Date 13 September 2023
Our Ref 23/01068/FUL

Town and Country Planning Act 1990 (As Amended)
135 Riverview Road, Ewell, Surrey

Conversion and extension of existing garage granted under 20/00589, to a one bed studio bungalow, in the rear garden of 135 Riverview road, whilst leaving a parking bay for 135a, as required under planning permission 20/00589

PROJECT: 135B, Riverview Road, Epsom KT19 OJR CLIENT: Mr R O'Sullivan
TITLE: Existing ground floor plan of studio in relation to 135
SCALE: 1:100 on A3 DWG NO: 682B/EX/100 REV:

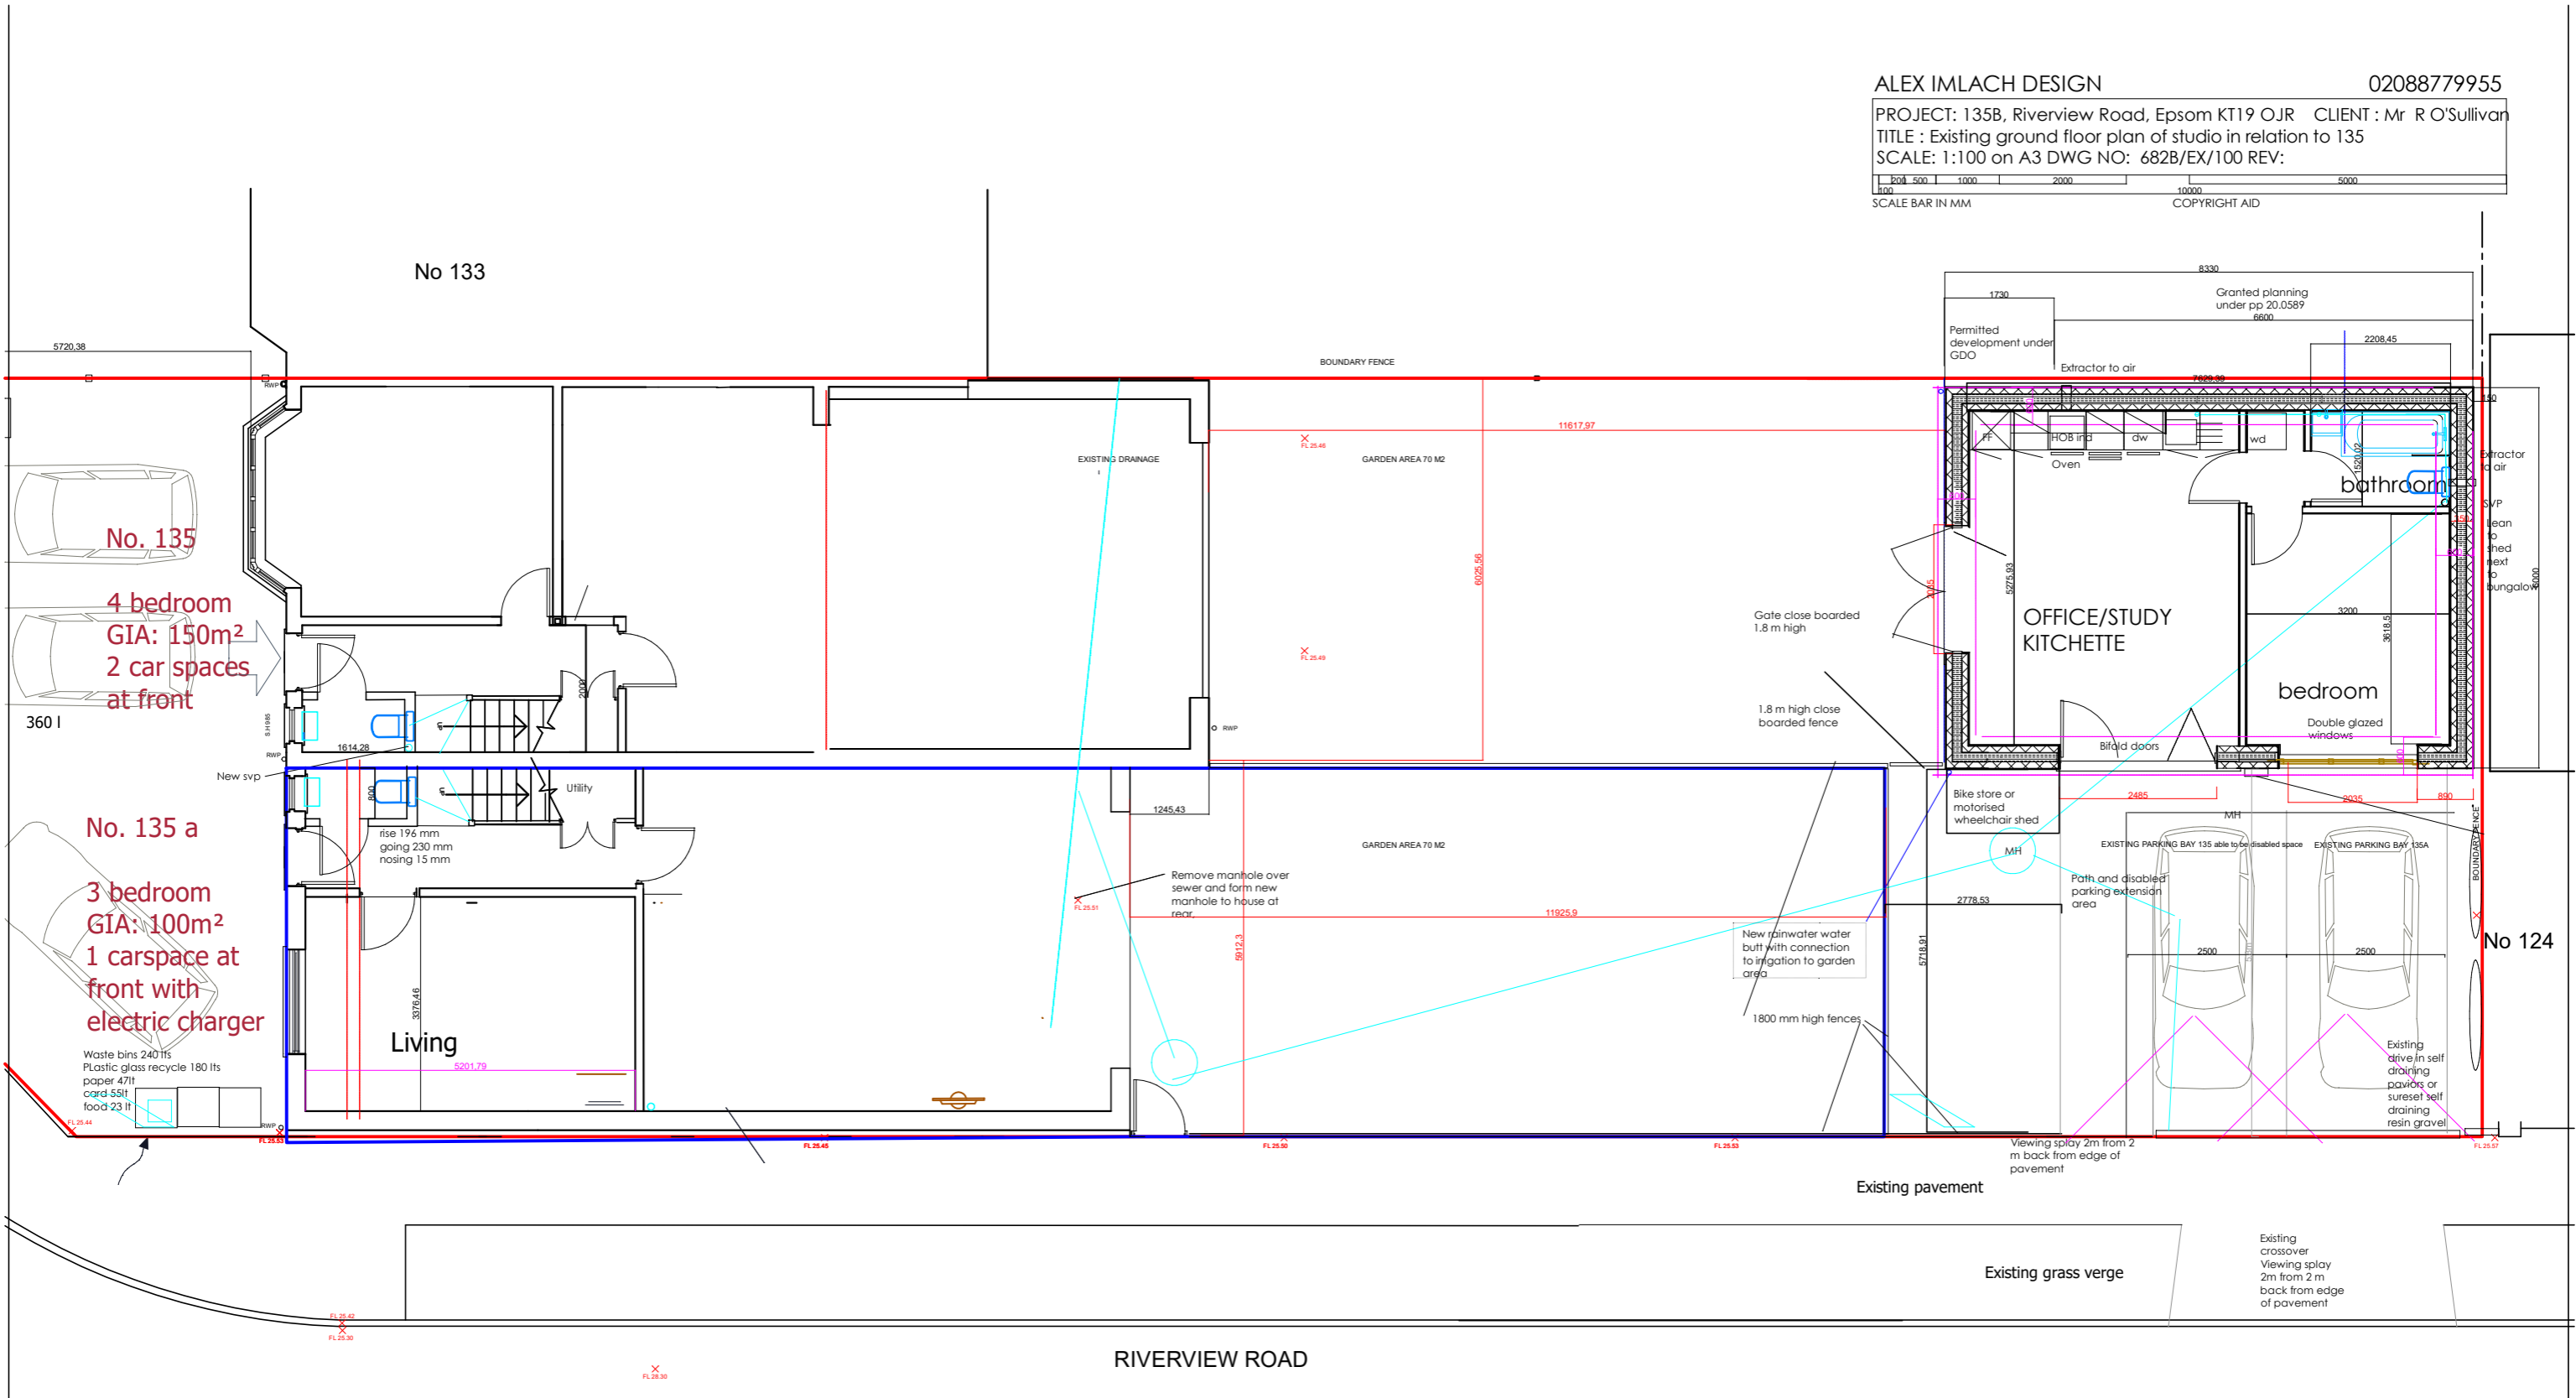
4 Please provide the approved plans prior to the garage being converted - labelled as such. Currently both the existing and proposed plans are the same. Only the proposed plans must show the garage as it has been converted.

PROJECT: 135B, Riverview Road, Epsom KT19 OJR CLIENT: Mr R O'Sullivan  
TITLE: Proposed ground floor plan of studio in relation to 135  
SCALE: 1:100 on A3 DWG NO: 682B/PL/110 REV: G

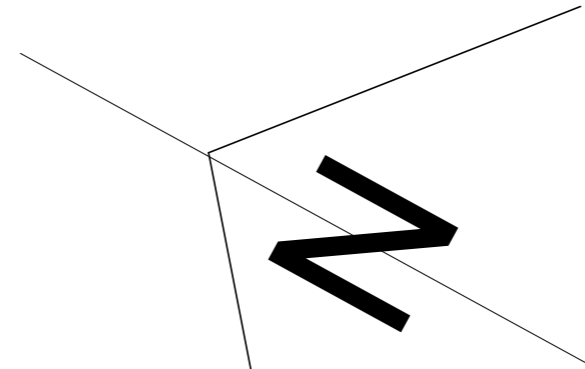
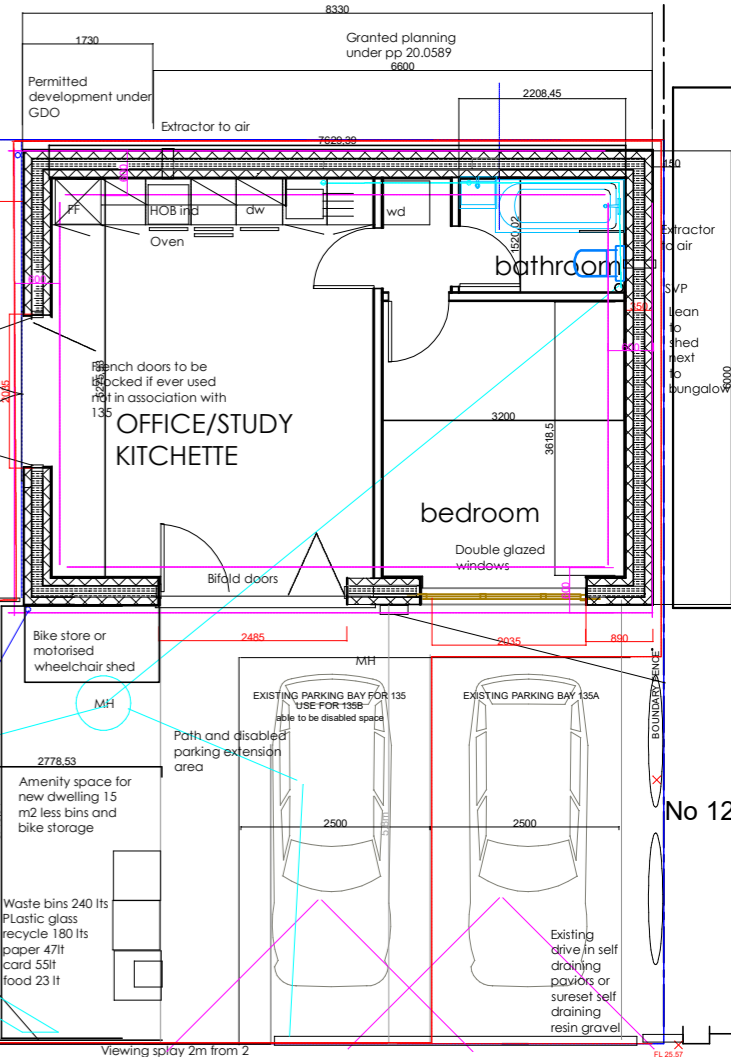
5 Please also clarify if the car spaces in front of the garage belong to Nos.135 and 135A (as labelled on the plans) and if there is any parking space proposed for the new dwelling.

6 Clarification also required for the remaining curtilage for each of the 3 units.

ALEX IMLACH DESIGN 02088779955
 PROJECT: 135B, Riverview Road, Epsom KT19 OJR CLIENT : Mr R O'Sullivan
 TITLE : Proposed ground floor plan of studio in relation to 135
 SCALE: 1:100 on A3 DWG NO: 682B/PL/110 REV: D

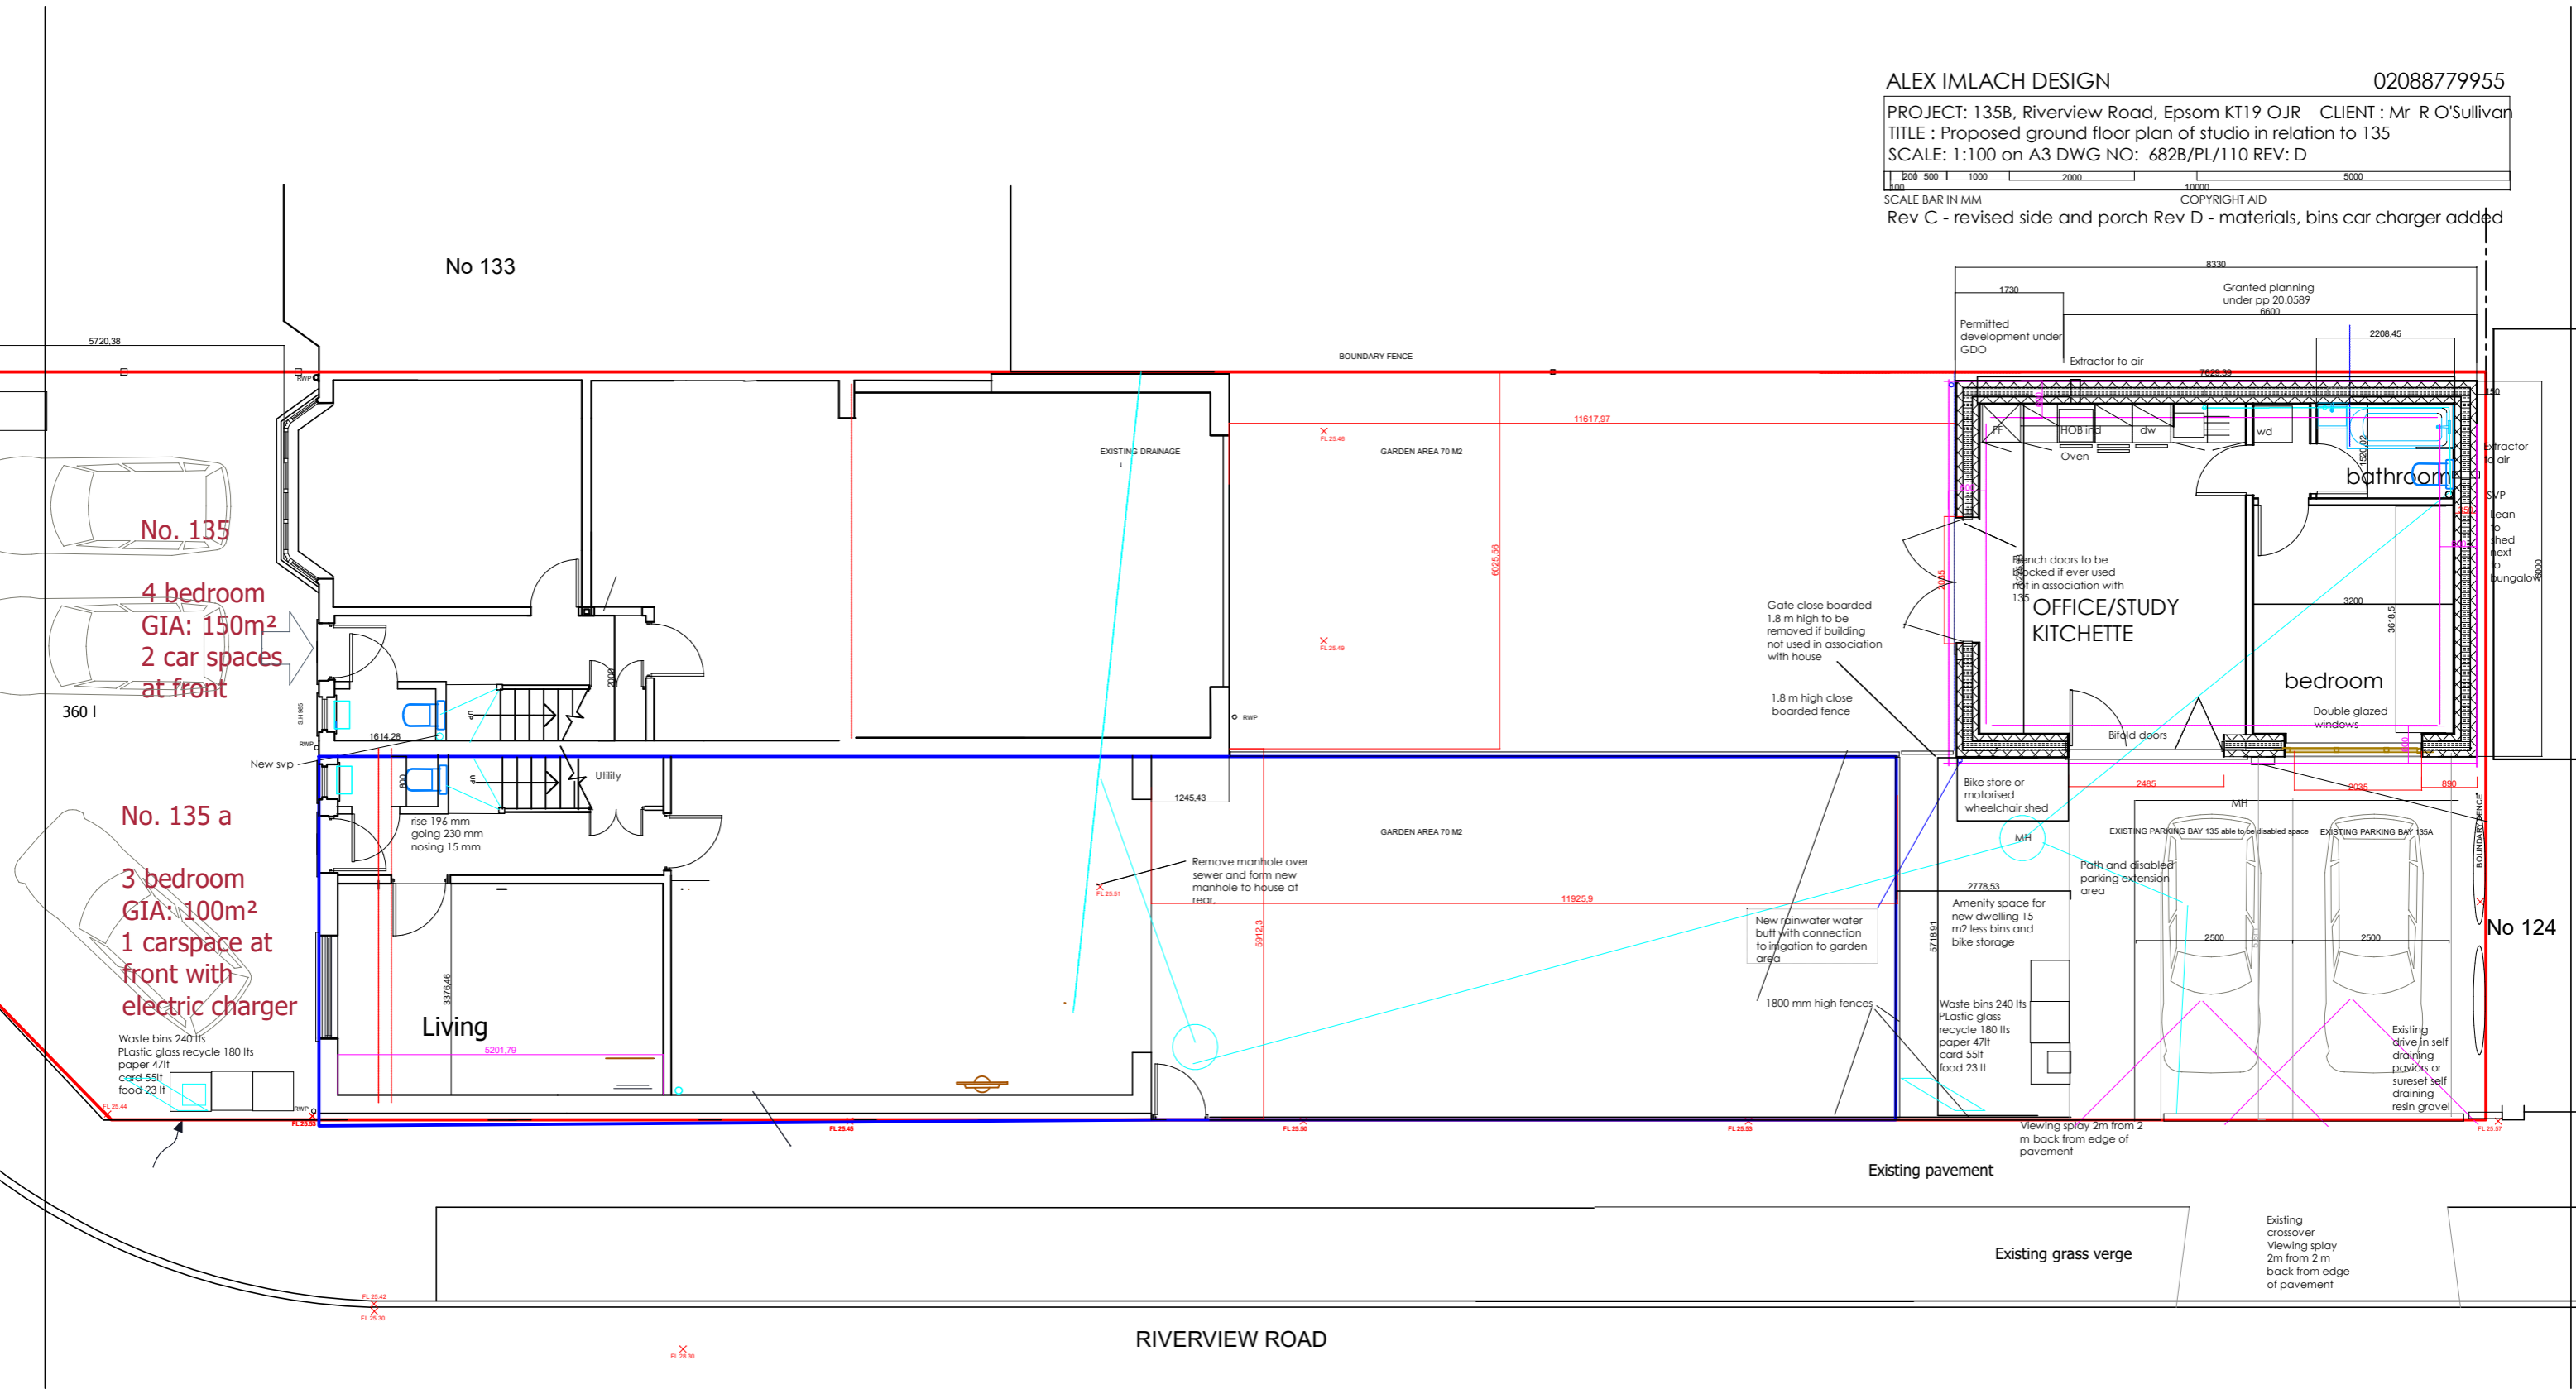
2 Incorrect Site Location Plan. This is a plan identifying the exact location of the application site, which must:- include a title stating the address of the site- include the direction of North- the red line is incorrect - it must also include the access to the highway as shown on drawing no.682B/PL/110 Rev:D. - you will also need to sign Certificate of Ownership B and serve notice to SCC Highways.
